Application for Removal or Variation of a Condition following Grant of Planning Permission or Listed Building Consent

Retrospective application for extensions to side and rear and first floor (an increase of 300mm to east elevation compared to previously approved applications 3/2021/0428 and 3/2021/1074) and the insertion of an additional window at ground floor on the eastern elevation. Obscure glass to sides of roof terrace and balcony as per existing approval. External stairs proposed to be re-positioned to rear (previously positioned on the East side).

Application 3/2023/0118

Condition 1 should relate to the updated drawings: 6219 P01J Proposed Elevations, 6219 P02J Proposed Floor Plans, 6219 P03I Proposed Site Plan. (All other referenced drawings to remain as current approval ref).

6219 - P03I

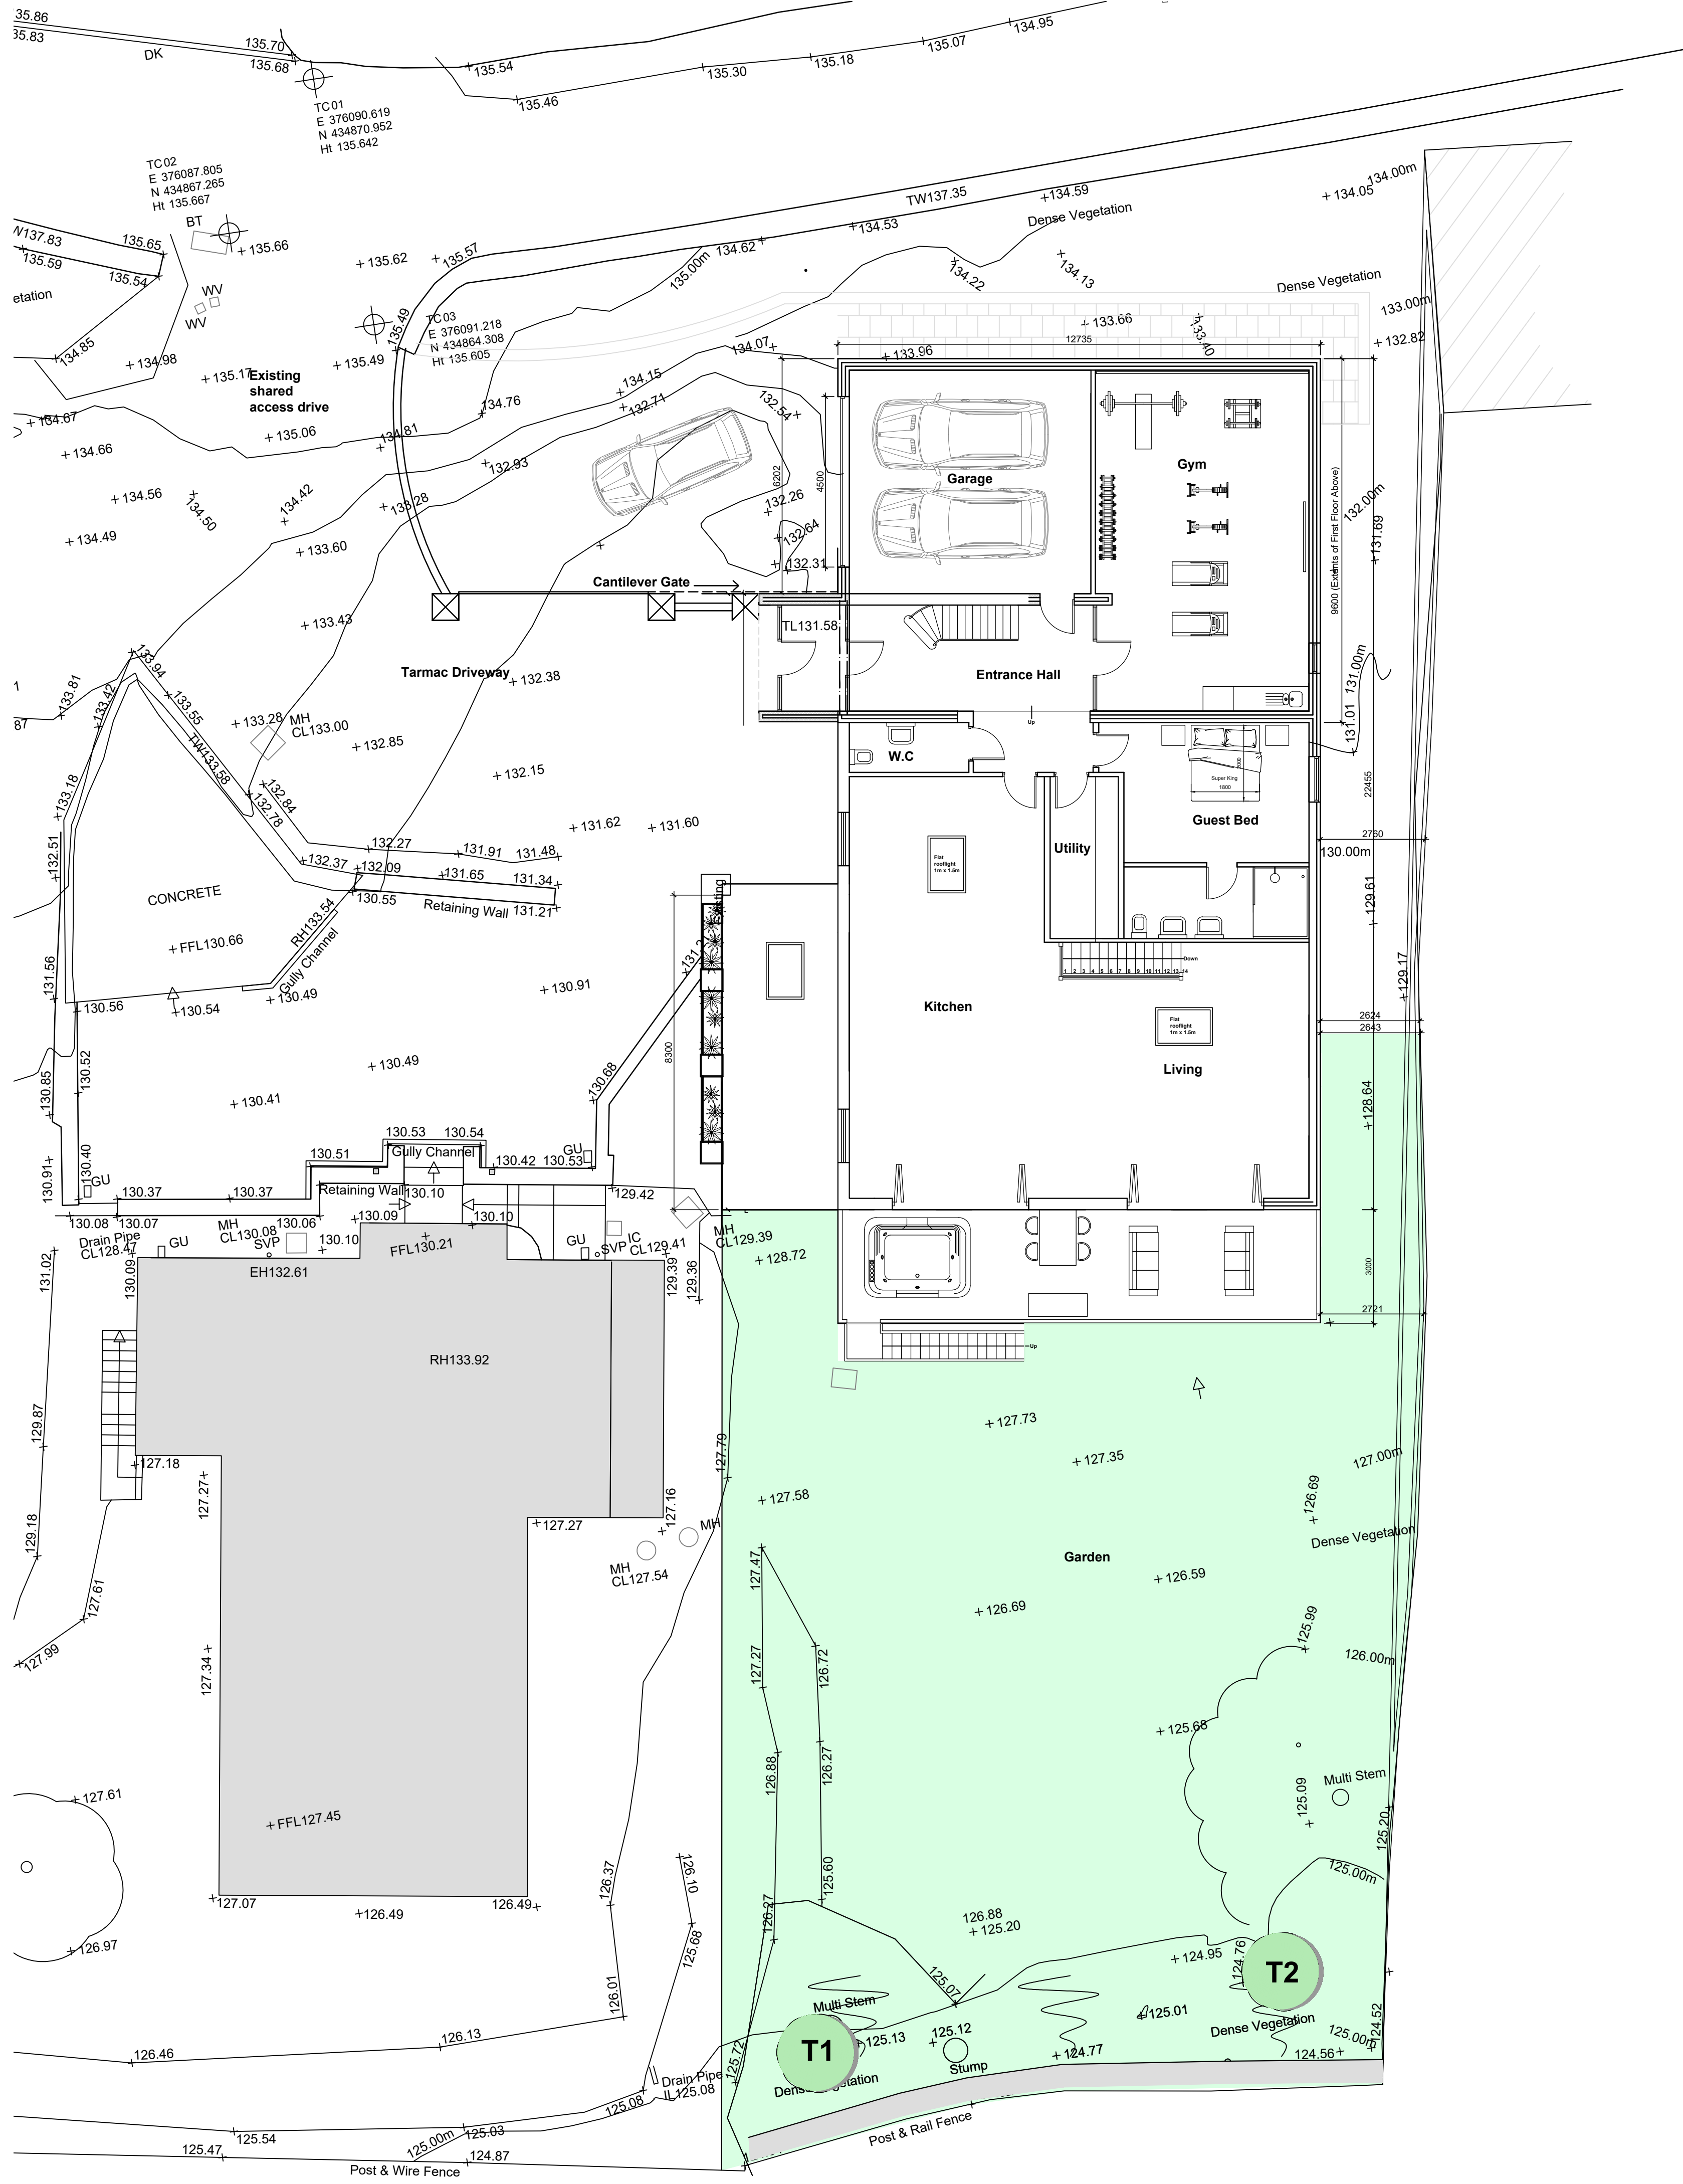
Drawing references to be updated to as built / in progress drawings following review on site. Privacy glazing reinstated with 1.1m metal railings towards rear garden. Minor amendments to window sizes and openers. External staircase repositioned on the rear (previously on the East side). All updated on Proposed Floor Plan and Proposed Elevation drawings.
